Comments for Planning Application 3/21/0094/CLPO

Application Number: 3/21/0094/CLPO

Address: 6 Bowlby Hill Gilston Hertfordshire CM20 2FZ

Proposal: Loft conversion with the insertion of 4 rooflights and window to flank elevation

PROPOSED NORTH EAST ELEVATION
1:100

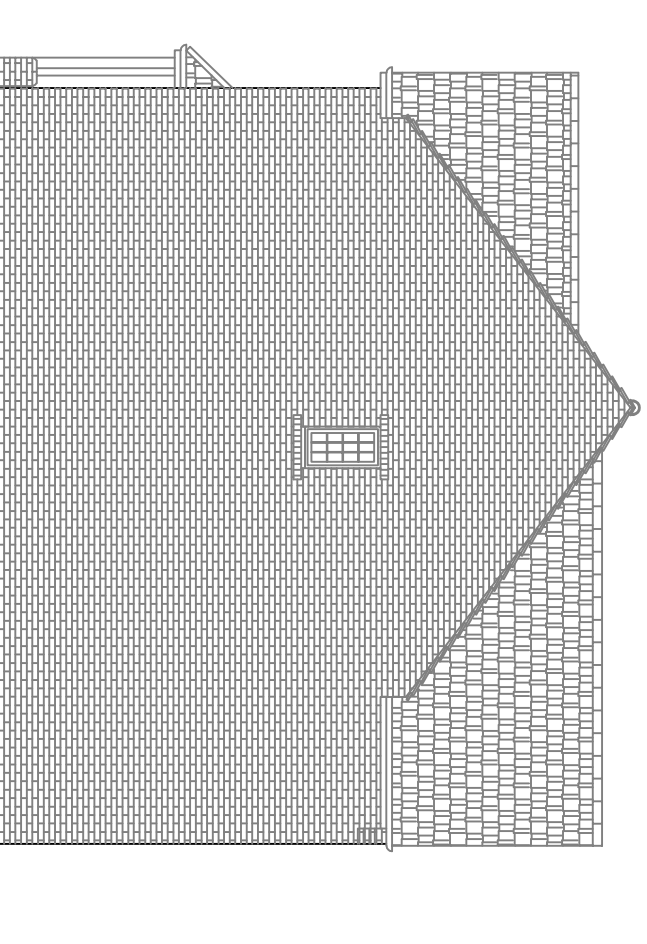
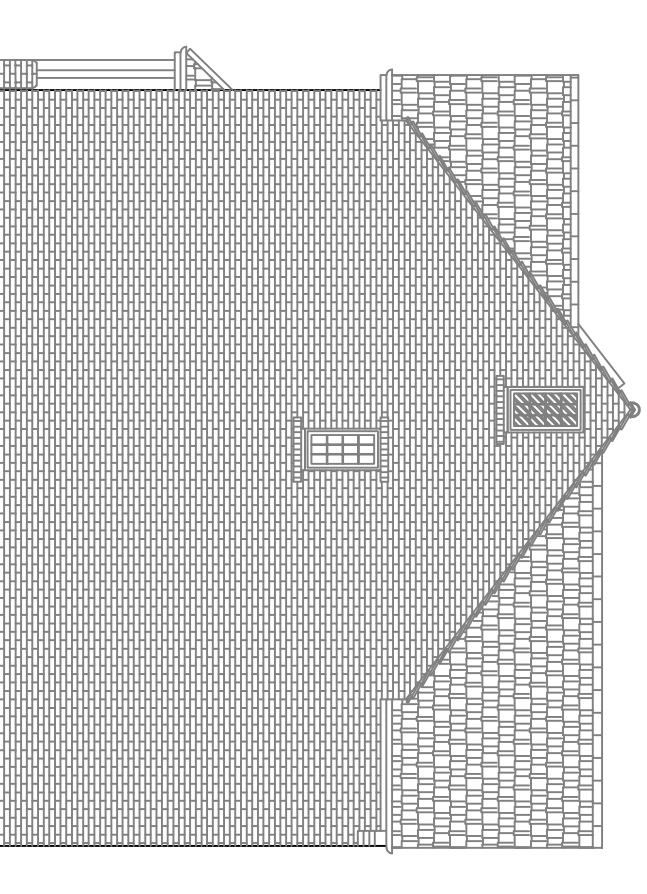
The new window on the North East elevation creates a new vantage point from which one can see into our bathroom, kitchen utility and studio above our garage.

Our driveway is enclosed within three tall walls: the sides of #6 and #7, and the front of our double garage and studio. Sound echos within these walls, and noise coming from this window would reverberate easily.

The large driveway between #6 and #7 belongs entirely to us (#7), i.e. not shared with any neighbours. The two existing windows, i.e. the one on the side of #6, and the other on the side of #7, are at the same height and symmetrical. The new window would detract from the current visual amenity, and would look as if #6 overlooked a shared courtyard, which is not the case.

- (a) the window on the North East elevation will be a fixed window, i.e. the window will not open, and
- (b) the window will have obscured glass.

We confirm that we agreed to points (a) and (b). The applicants' architect has updated the plans accordingly, and submitted them to the East Herts Planning Office on Monday 25th January. Our understanding is that the Planning Office will update the planning application accordingly for the public records.
